February 10, 2023

RE: Technical Review #2 – Response to Comments (SP22-004)

DRAINAGE & GRADING PLAN

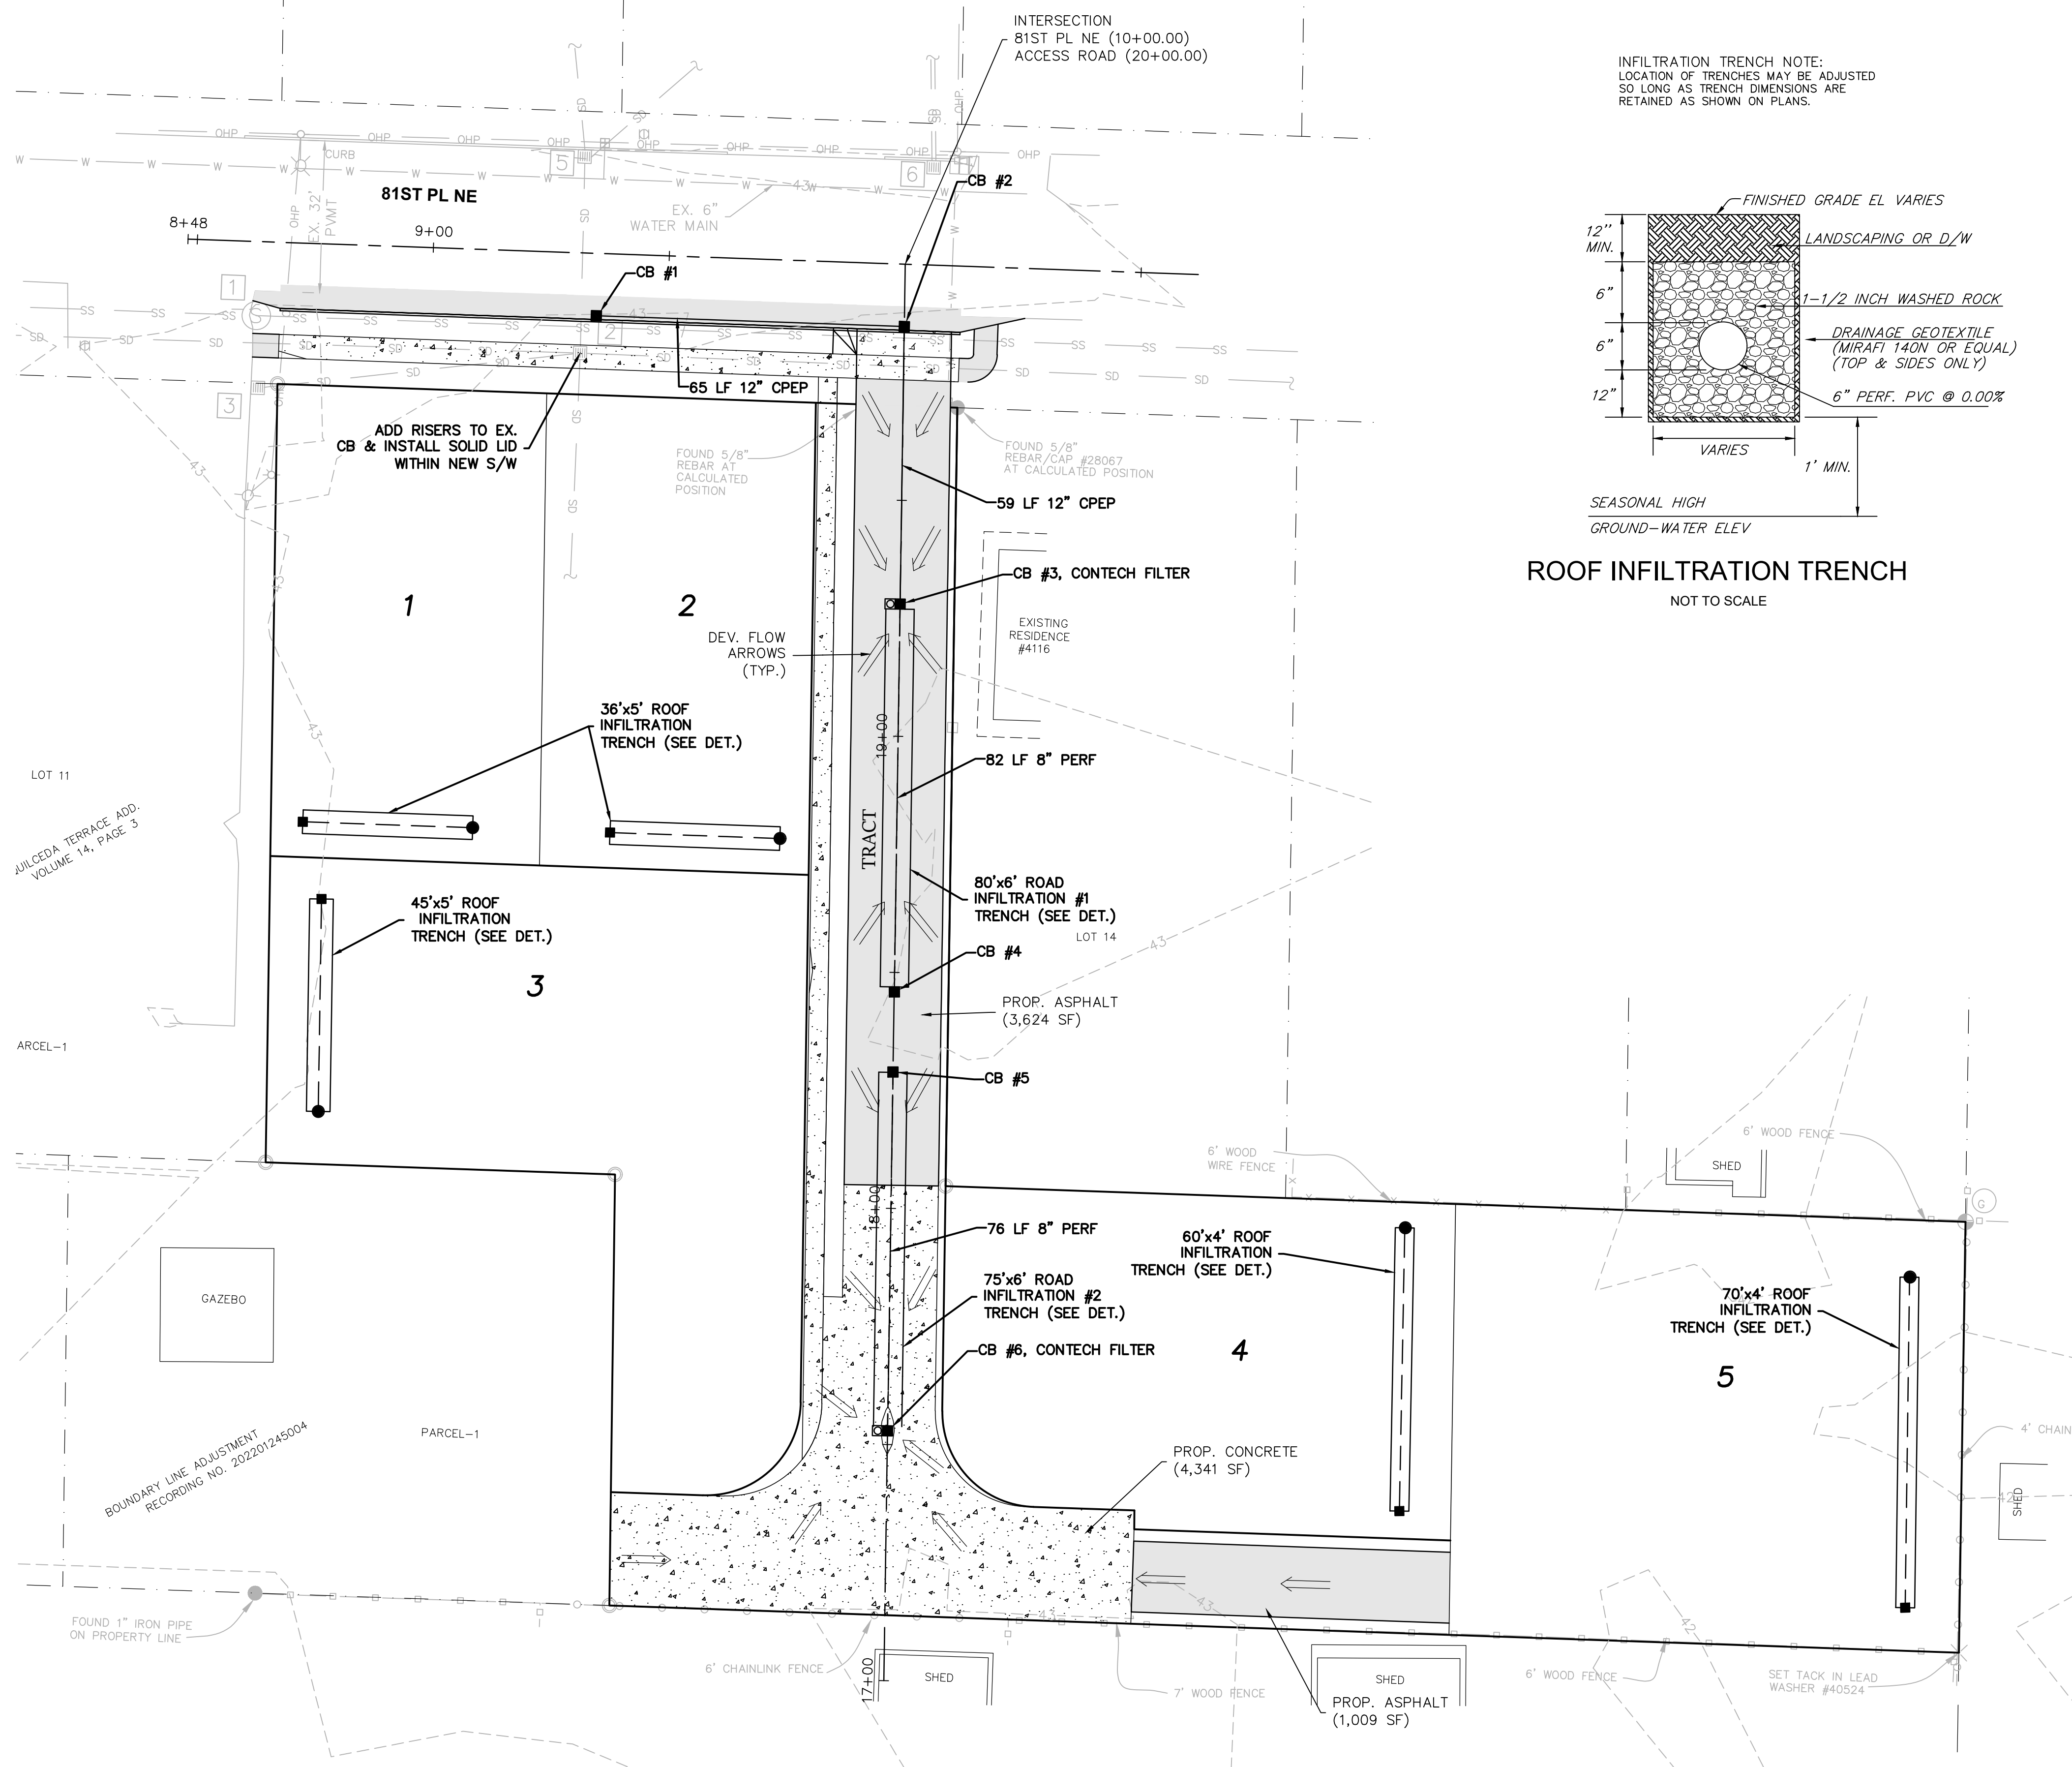
1. The water main is now shown to be 8" and a blow off assembly has been added to the end of the line. The hydrant has been moved behind the sidewalk.
2. The drainage design has been modified so that the infiltration trenches will not be within the water and sewer easement areas. A 20' sewer and water easement has been added to the plans.

SEWER & WATER PLAN

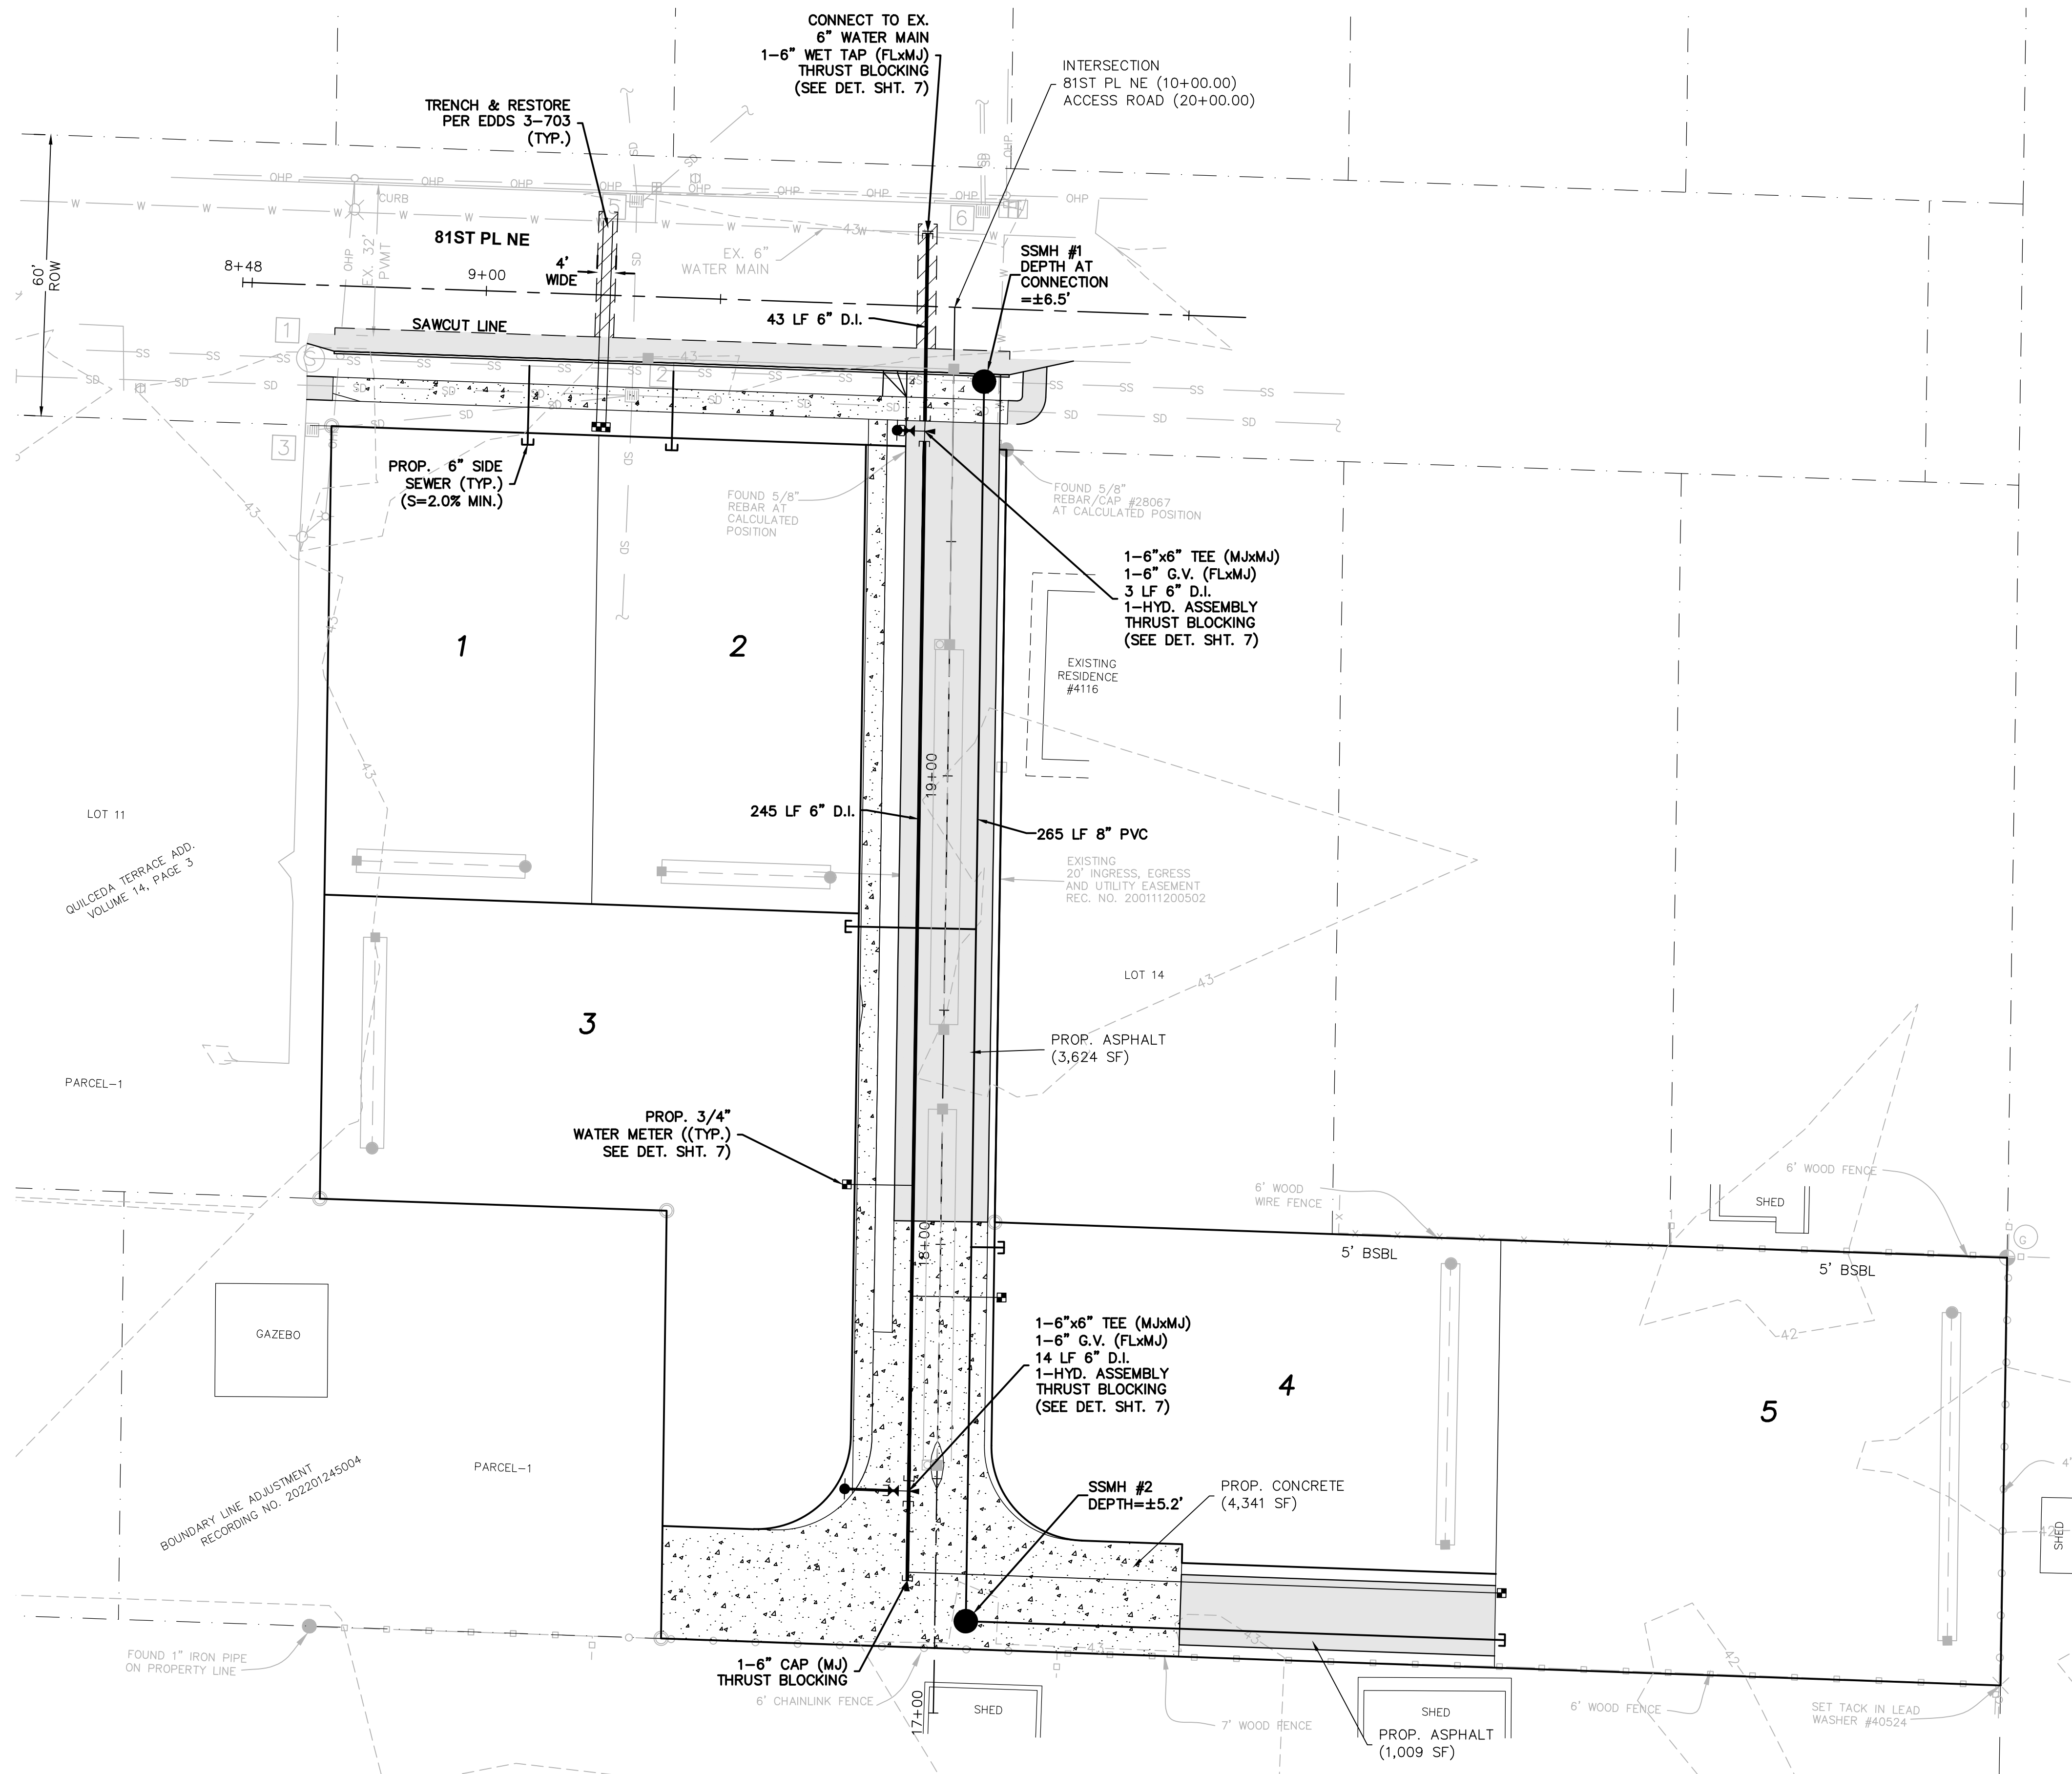
1. New water line is now shown to be 8".
2. A blow off has been added to the end of the line.
3. Connection details to the existing main have been revised.
4. This comment was missed, but is minor enough to be addressed on the construction plans.

81ST PLACE SHORT PLAT
SP22-004

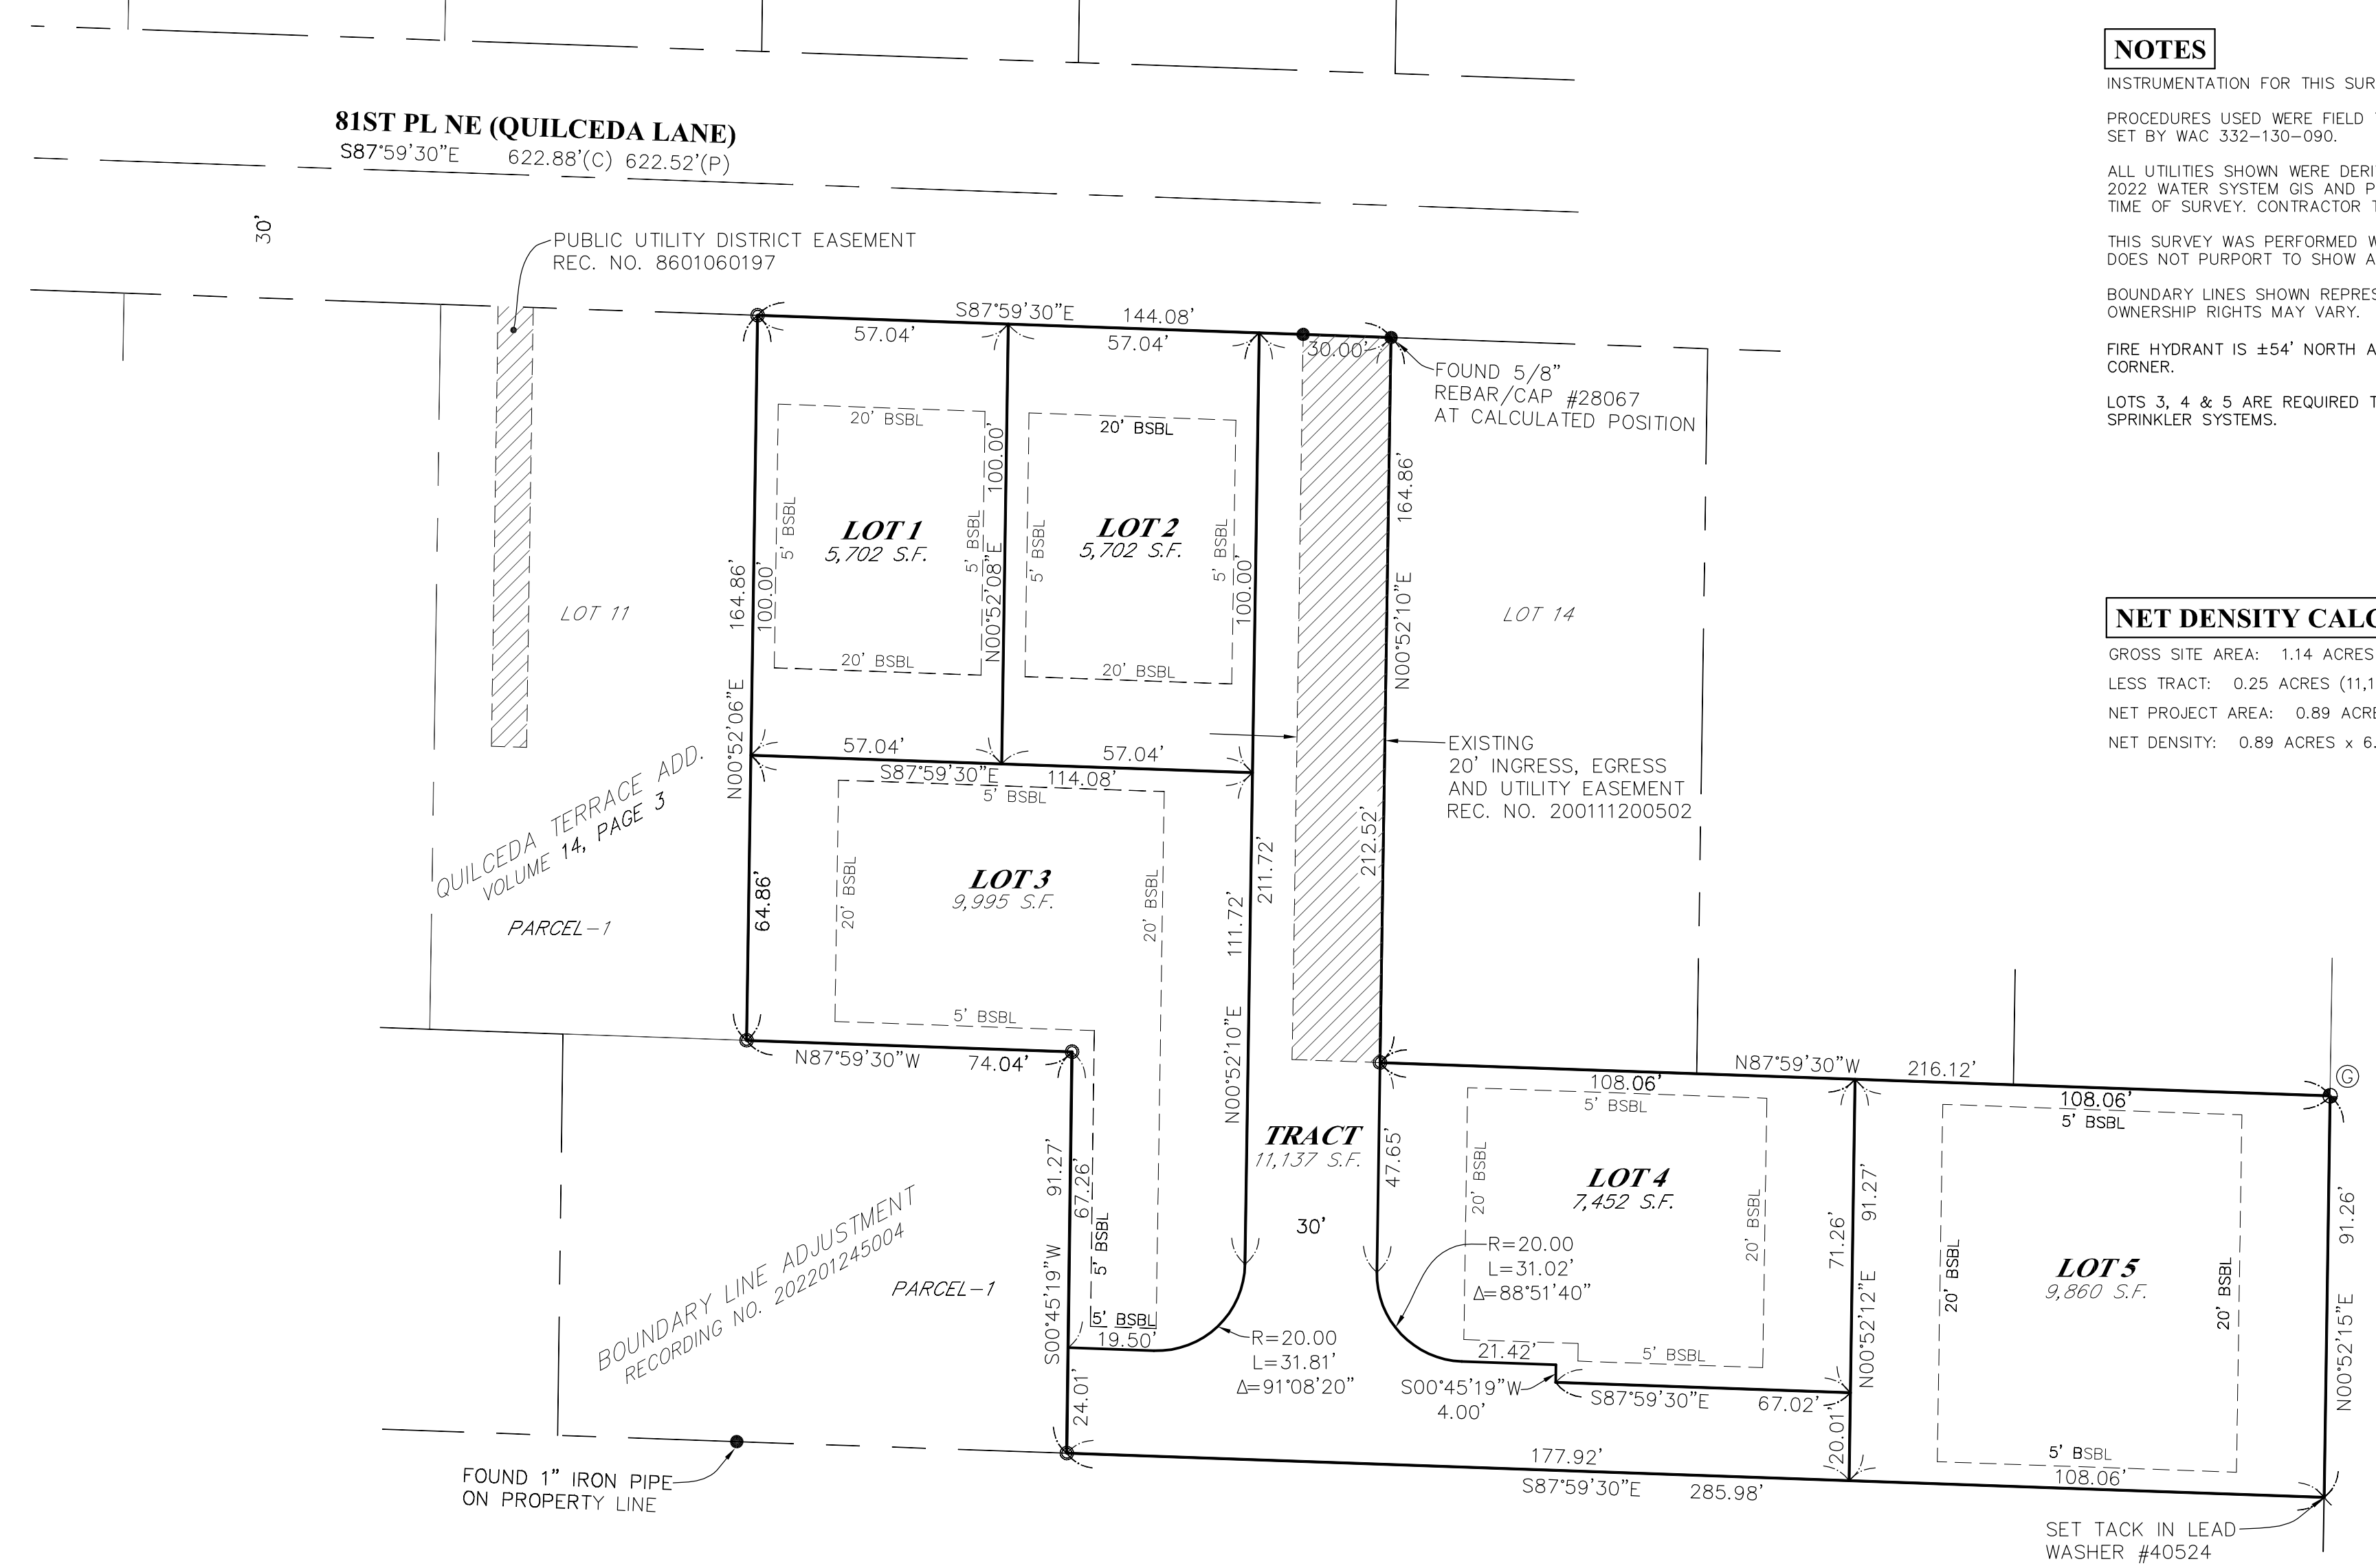
1. The BSBLs on Lot 3 have been revised.
2. The entire driveway to Lot 5 is now shown as concrete or pavers.
3. An on-site turnaround detail has been added to the plans for lot 5.
